**Re: Construction of a 2 storey 220 V GIS substation known as 'Mooretown', 4 underground transmission cables and all associated and ancillary site development works and construction works.
Lands adjacent to Huntstown Power Station, North Road, Finglas, Dublin 11.**

**Report of the Chief Executive Fingal County Council on proposed Strategic
Infrastructure Development at Lands adjacent to Huntstown Power
Station, North Road, Finglas, Dublin 11.**

FCC Reference: **SID/03/21**

ABP Reference: **ABP-311528**

Drawing file: Application Drawings / 60641561-DWG-729-SERIES COIL DELIVERY - OPTIONS.pdf

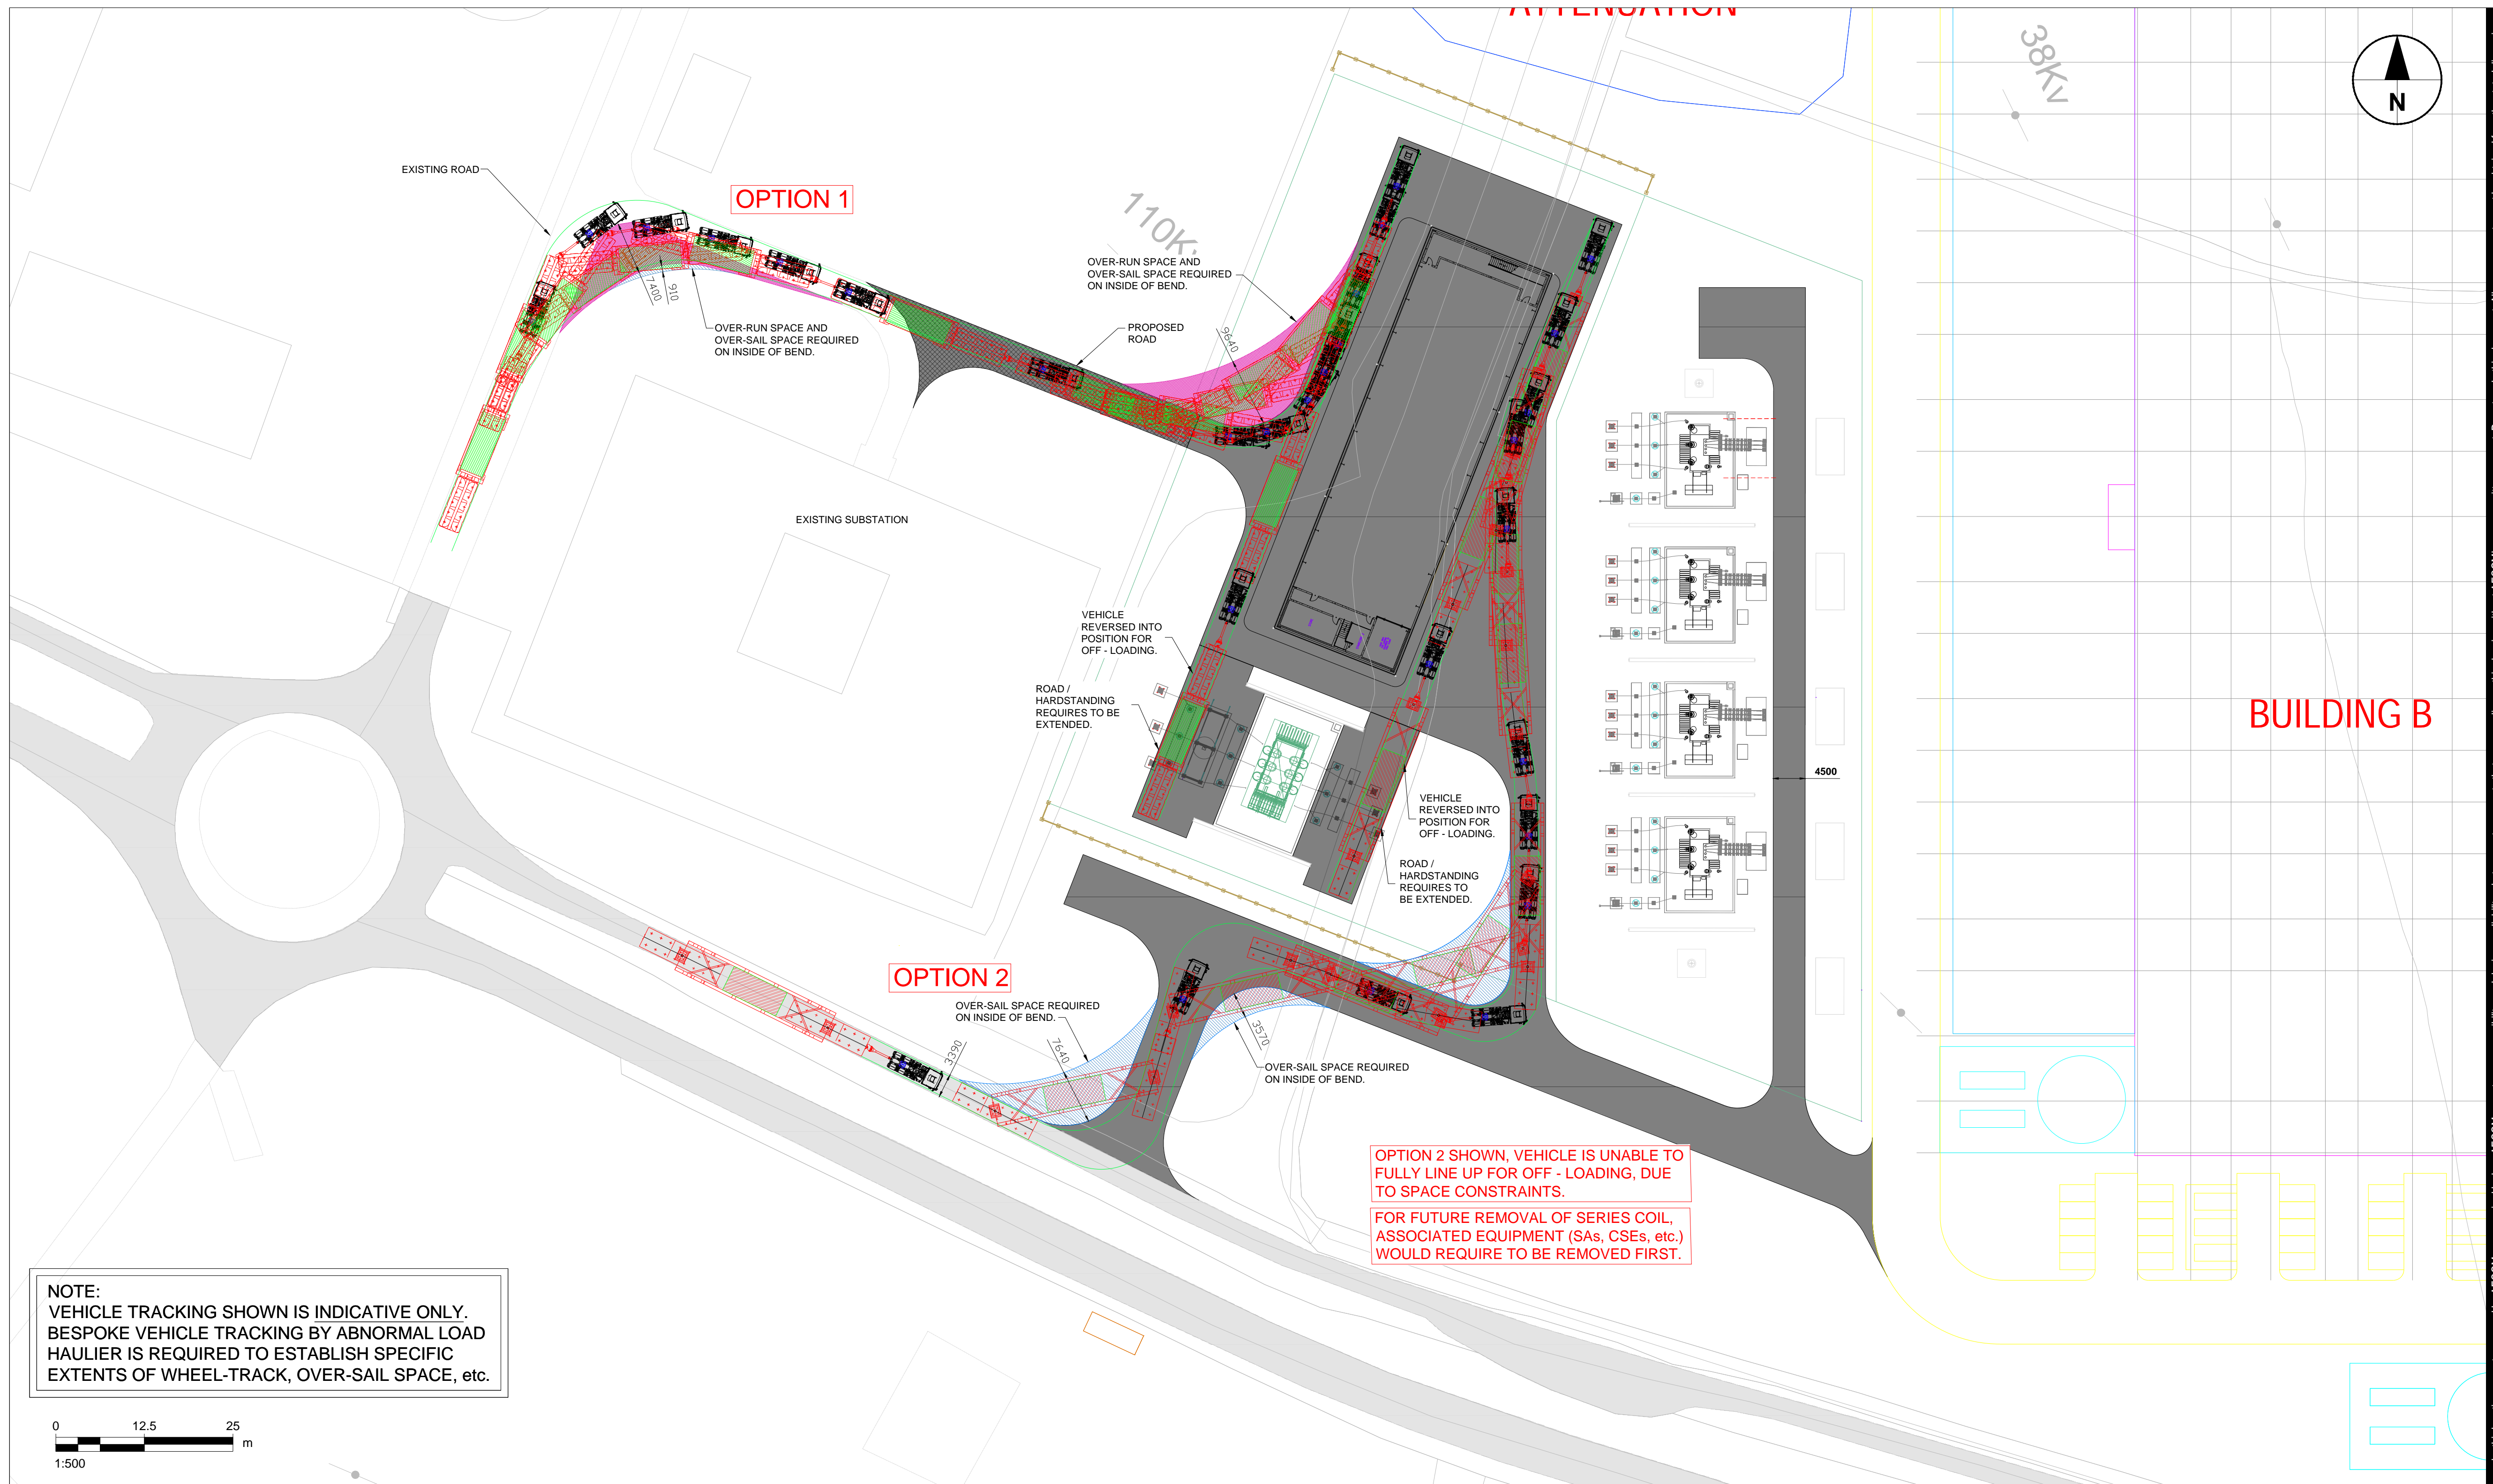
The transport delivery options for the transformer refer to accessing the site only. Both are acceptable and the proposed overspill areas on the inside bends as shown should be for infrequent use or temporary uses only and the permeant kerb line maintained with bollards or similar when not in use.
